**RE: Heritage Council comments on New Restaurant & Micro-brewery, Overseas Passenger Terminal (Tenancy 5), Circular Quay Way, The Rocks, Sydney (SSD 7683).**

I refer to your letter dated 28 November 2016 inviting comments on the above State Significant Development application for a new restaurant and micro-brewery at the Overseas Passenger Terminal (Tenancy 5), Circular Quay Way, The Rocks.

3 February 2017

Level 1 Proposed
1:200 @ A3
July 2016
SK
257_ADA_012 F

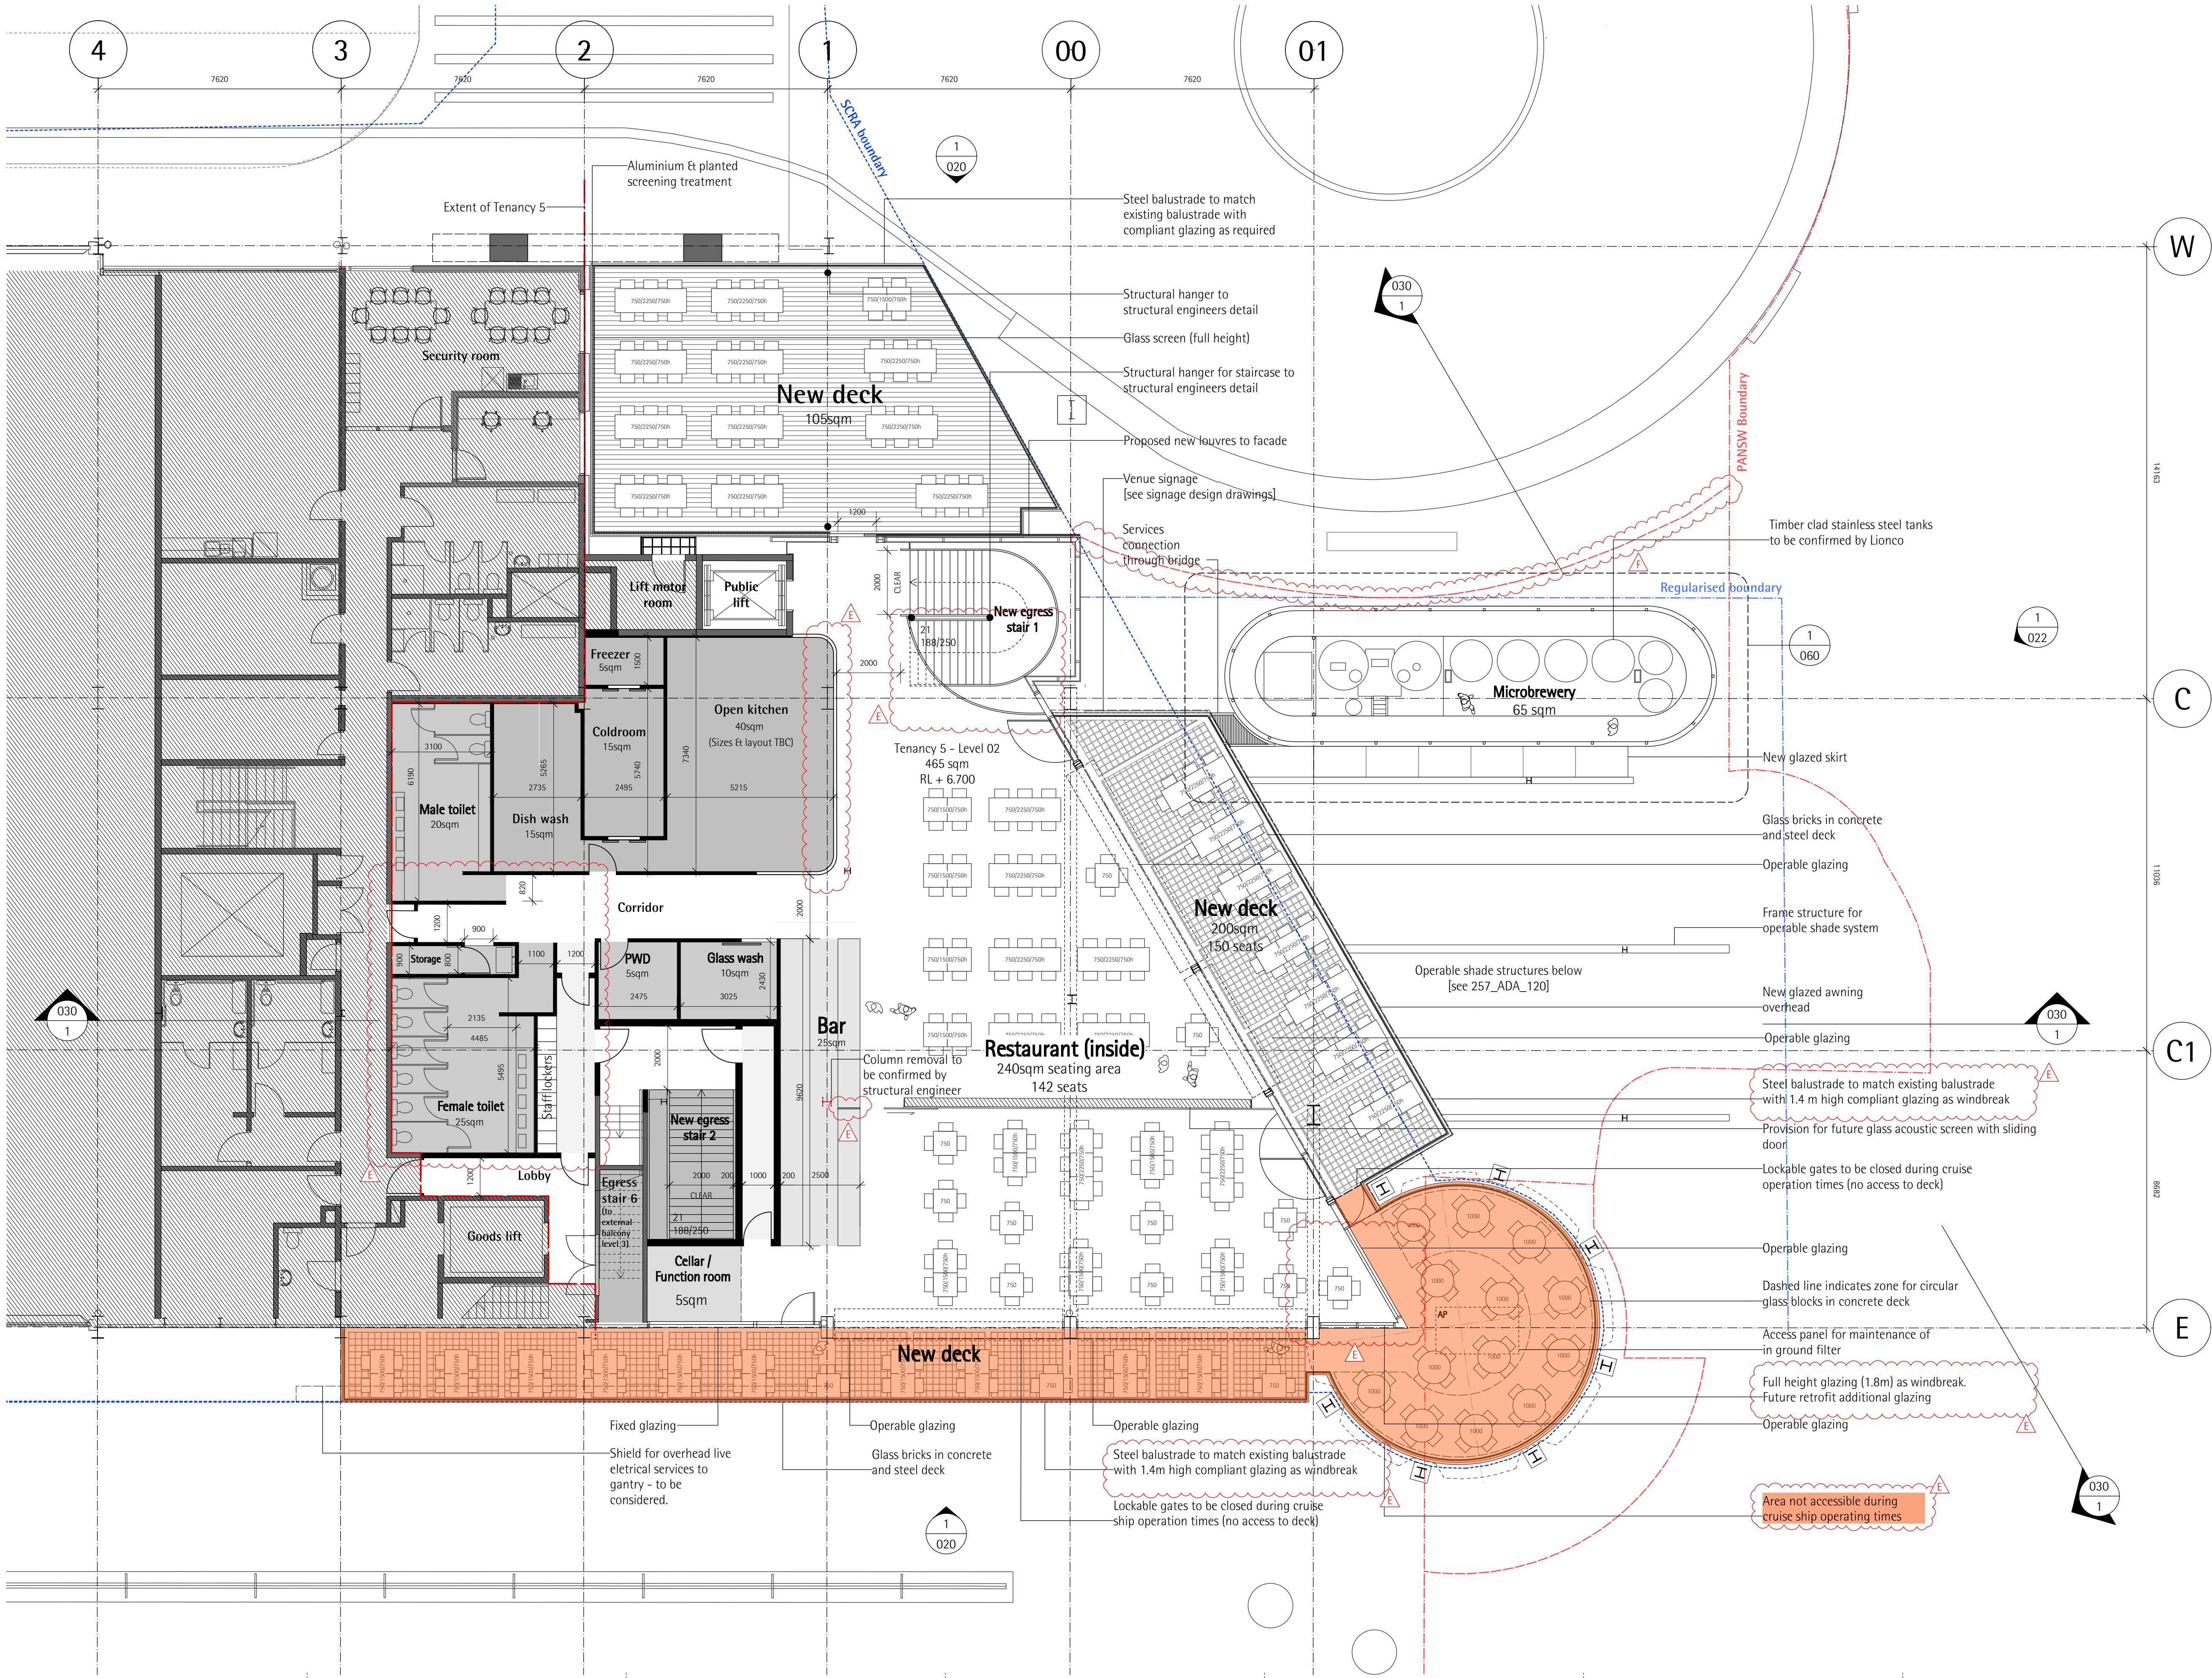
The introduction of an outdoor seating area within the double height space (level one) will limit the transparency of the structure and significantly obscure views to the Opera House. Further, it is also unclear whether this outdoor seating area will utilise awning shades, as per the existing awnings on levels above. These elements would further impact on primary views to the Sydney Opera House and are not supported.

- 1) The proposed micro-brewery pod structure be deleted from the proposal and alternate locations explored including the placement of the element wholly within the existing building envelope.
- 2) The proposed outdoor seating area located within the double height space of the existing tower structure is to be deleted from the proposal and the open character of the tower is to be retained.

1 Brew-pod Elevation
Scale 1:50

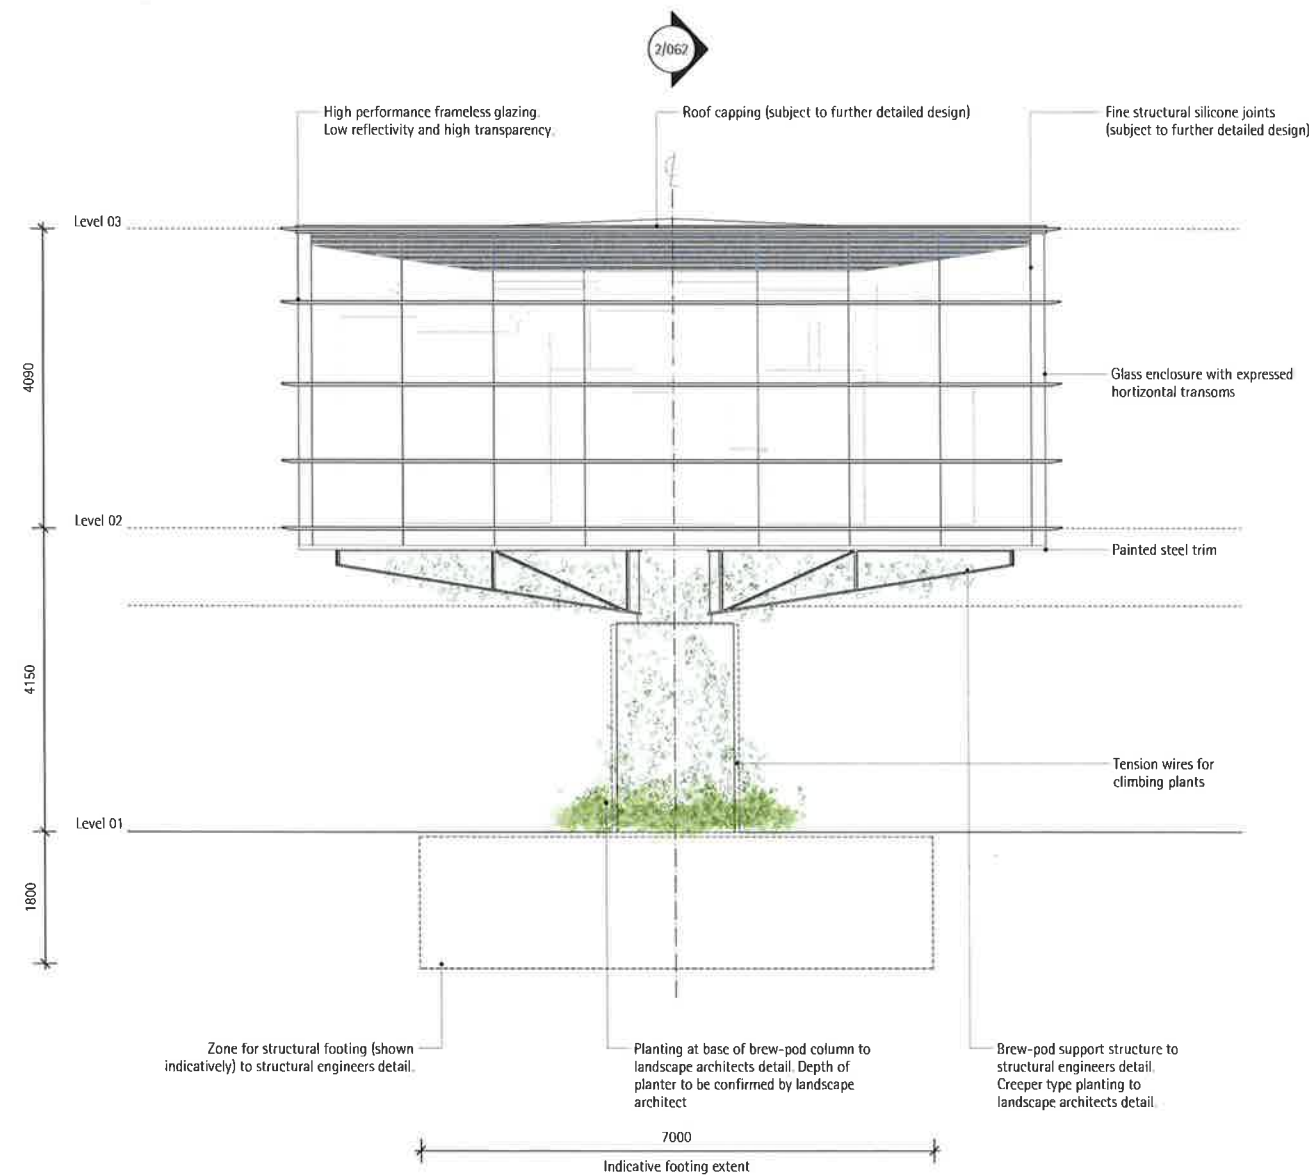
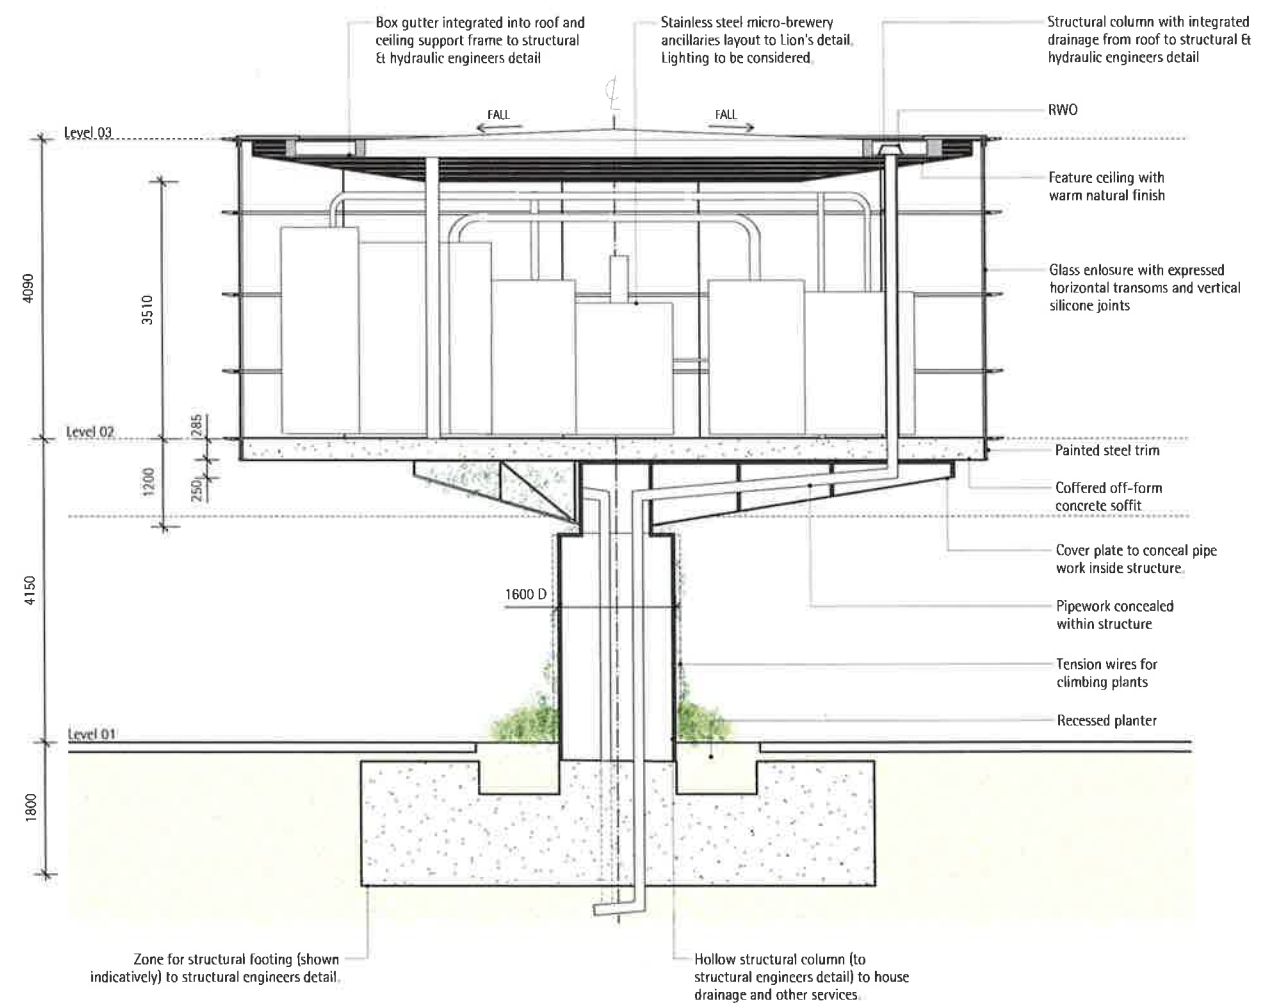
- The proposed free standing micro-brewery structure (8.24m high) is a separate external element positioned to the north of the OPT. Its placement on the site will adversely impact views to the Sydney Opera House (SOH). The views and vistas to the SOH and its buffer zone are a significant element in the marine landscape of Sydney and the micro-brewery structure obscures a primary view, as illustrated in the view analysis submitted with the application. The proposed brewery is also likely to have an adverse impact on the setting of the Campbell's Store. Therefore the location of this proposed element is not supported.

It is considered that a better option would be to locate the micro-brewery wholly within the existing building envelope. Further, the applicant should give consideration to the retention and recovery of views and vistas to the Opera House when considering future proposals.

- The Statement of Heritage Impact notes that the primary views to the SOH are currently obscured by cruise ships berthing at the OPT, which implies justification for the placement of the micro-brewery structure. These intrusions into the view corridors are temporary. The micro-brewery structure would permanently obscure views. This justification is not accepted.
- The proposed works to introduce an additional outdoor dining area within the existing tower structure of the OPT will have an adverse impact on views to the SOH. Currently the tower provides an unenclosed double height space up to level two of the OPT. This allows visibility through the structure, and frames views to the Sydney Opera House, in particular to the Bennelong Shells.
